City of Albuquerque

Ref: Construction Plans for the National Heating Company

K15/D29

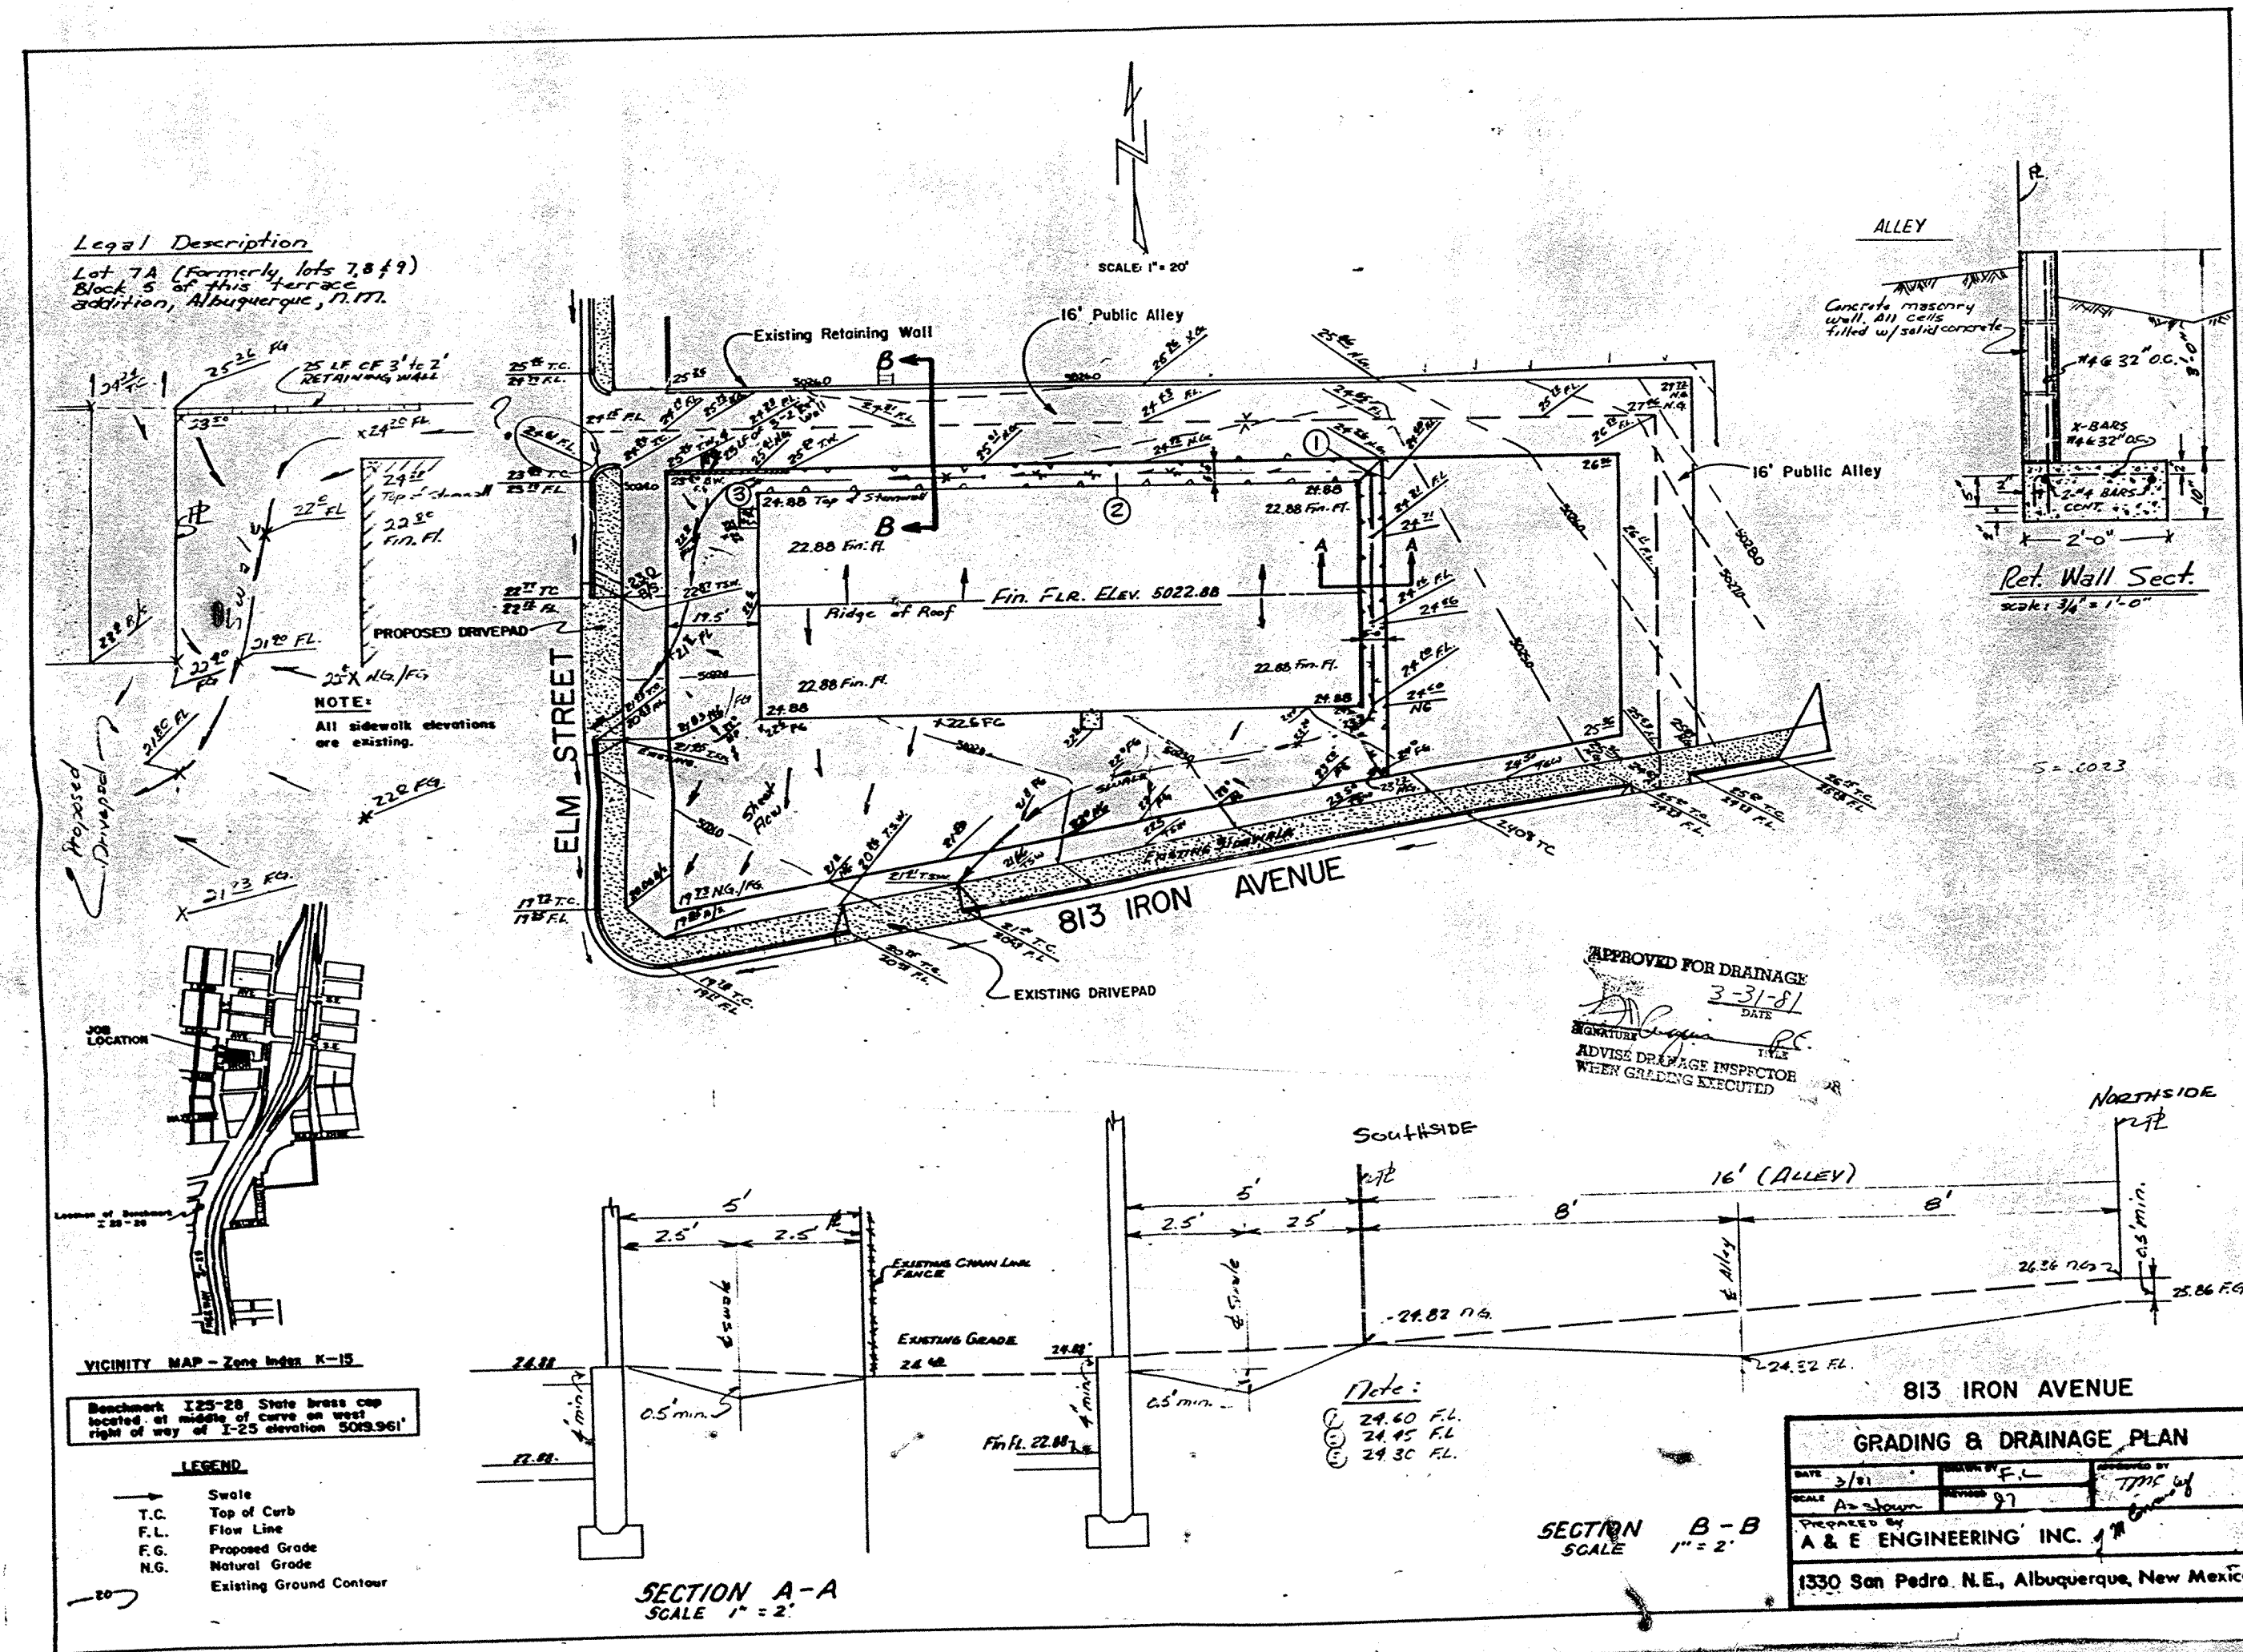
I have problems with the grading and drainage plan submitted with the referenced plans. The grades may not in particular be consistent with the needs of the City for the alley or for the needs of your neighbor to the east. It is conceivable that in order to provide ultimate design and construction of the ultimate grades for the alley, a small retaining wall may have to be built at the northeast corner of the property.

I have indicated to you the three options available for the proper design of the alley, but it seems that retaining a private consulting engineer may be the expedient and fastest way. This consultant will have to submit to the City a drainage and grading plan and establish the grades of the alley in a manner acceptable to the City Engineer's Office. I believe that Mr. R. S. Heller will consider granting conditional approval to the construction plan but will withhold the Certificate of Occupancy if the project is not completed in a manner satisfactory to our office. Concurrence will be granted by the City Engineer upon commitment by the owner to the submission of an acceptable plan for the alley and grading plan as indicated.
